Memorandum

To:	Norine Allerdice	Date:	October 27, 2022
From:	April Ng		
Project:	Butenwieser/Wiley Residence 6838 96 th Ave SE Mercer Island, WA 98040 King County APN 302405-9010	File No:	2205-199
Subject:	Building Permit Review 1 Response

The comments are restated below, followed by responses. Updated drawings have been clouded with Revision 1: 10/27/22 Building Permit Resubmittal.

C200A

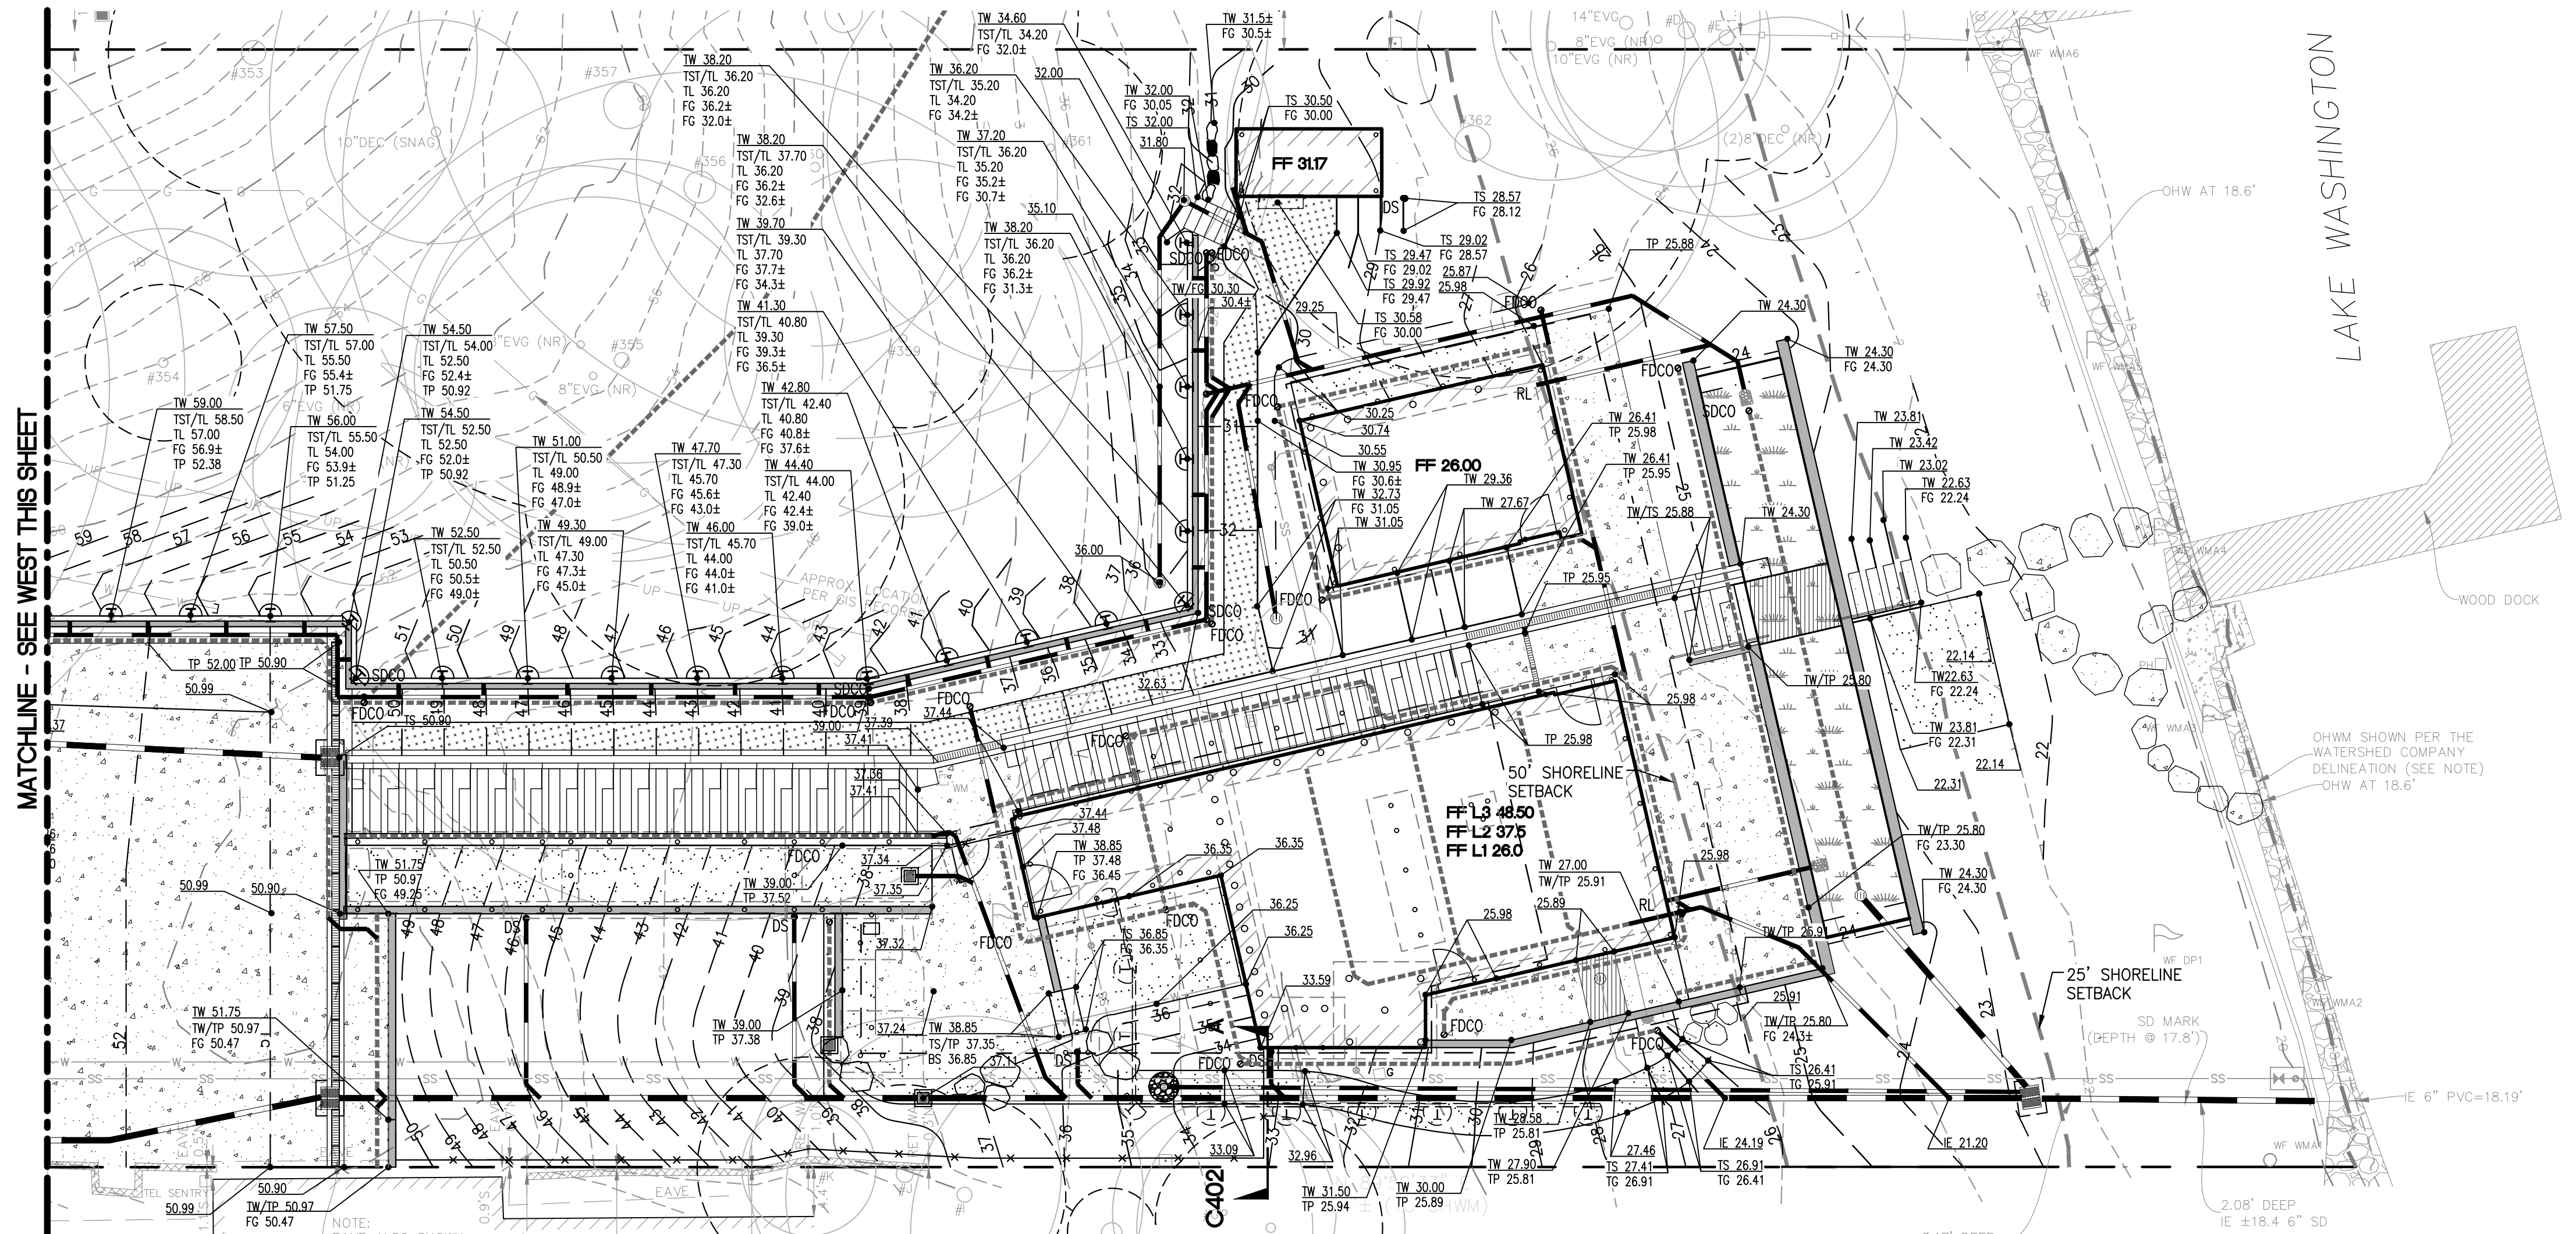
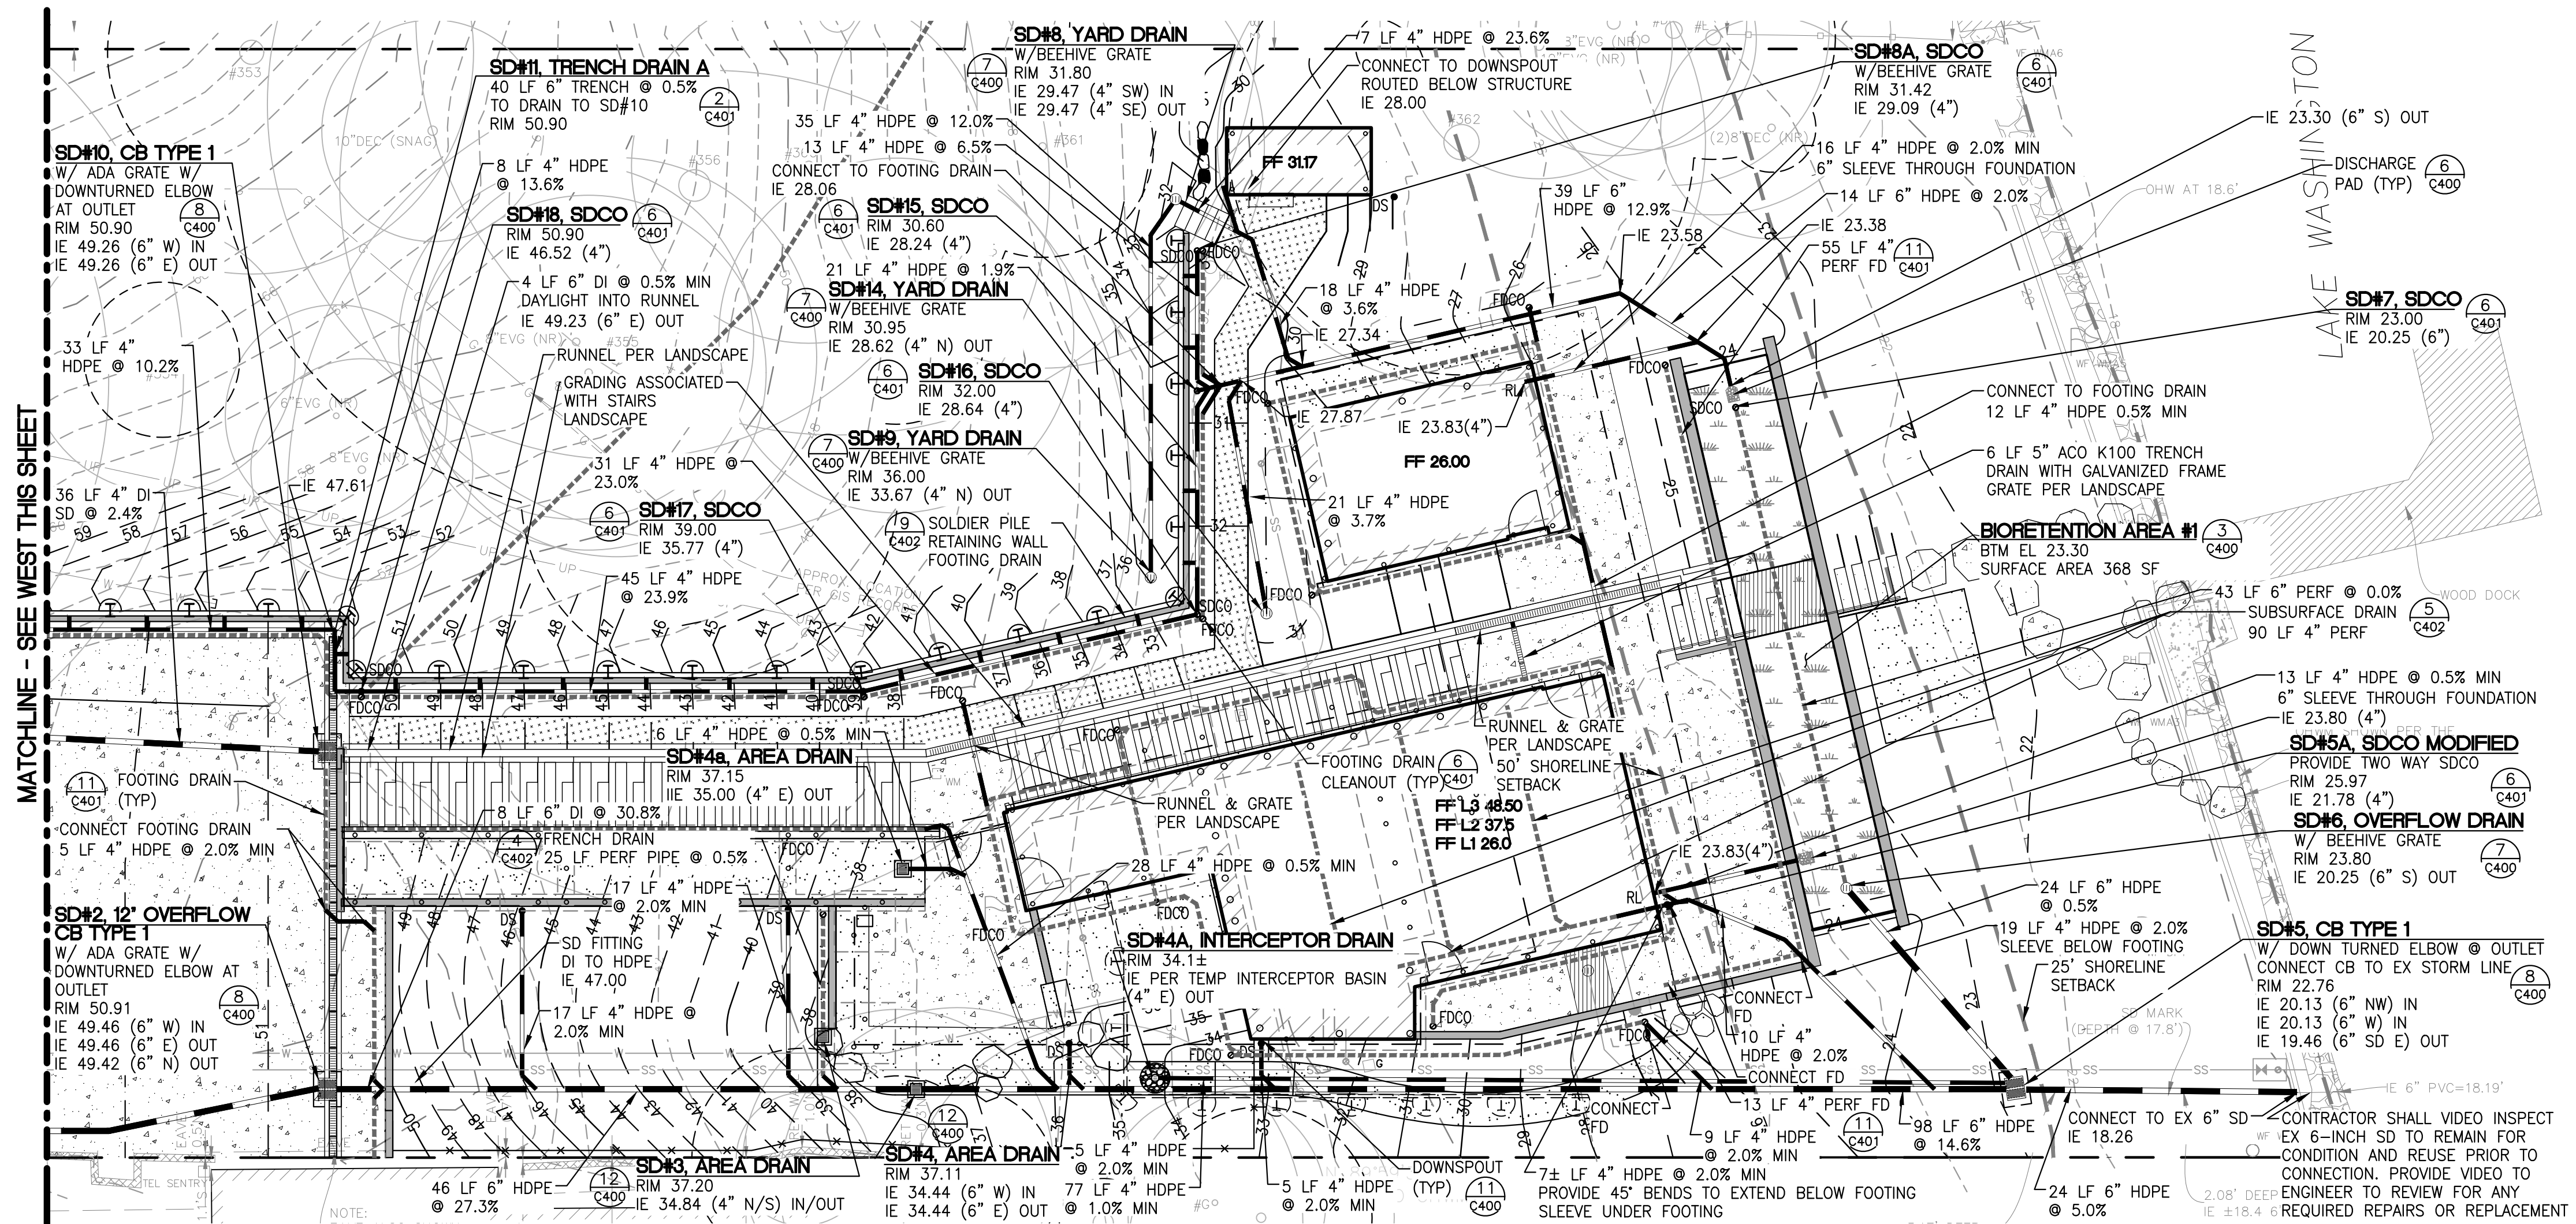
C200A Geotechnical engineer to review temporary open cut required at this location. The recommended temporary open cut angle of 1.5H:1V in the geotechnical report would appear to encroach on the adjacent property. Provide recommendations on how to accomplish this excavation. Provide a section detail for clarification.	The geotechnical addendum dated April 26, 2022 (Revised August 16, 2022) includes recommended temporary shoring information. The structural foundation at the building has been revised to reduce the extent of temporary shoring along the southern property line. Reference S112, 3/S303.	S112, 3/S303
L604 Geotechnical engineer and landscape architect to review proposed planting options and verify that the options are in general	Geotechnical engineer and landscape architect reviewed planting schedule and general planting notes for the ECA/restoration areas. It was agreed that the plant schedule is appropriate, however the ECA/Restoration	L603, L604

<p>(For Civil and Architect) Tree 362 is shown with grading shown within the project arborists limits of allowable disturbance on sheet C200A. The tree protection is shown only 4' away. Increase the tree protection to 11' from tree face, call this distance out. This will allow chain link fence to be anchored into ground at the correct location and be inspected. The demo/soil cut for the new house location will require the project arborist or equivalent on site to locate and prune roots.</p>	<p>very minimal. While the survey only provided 2-foot contours, LPD has provided 1-foot contours which is intended to mimic existing grade. Since there is proposed work in this area, the tree protection fencing where possible has been shown at 11 feet. Notes have been provided concerning the limitation of work within the RLOD.</p>	
<p>C200A (For Civil) Please put the trees and tree protection and utilities on the same sheet and remove civil call outs. If utilities/grading are within saved trees arborist given limits of allowable disturbance. They should be tunnel/bored or air excavated under arborist supervision. See previously provided checklist.</p>	<p>Due to the confusion line work when existing and proposed is shown on the same plan, LPD has provided an additional Tree protection plan for the proposed condition to show utilities and grading within the tree protection zones.</p>	<p>C101A, C101B</p>
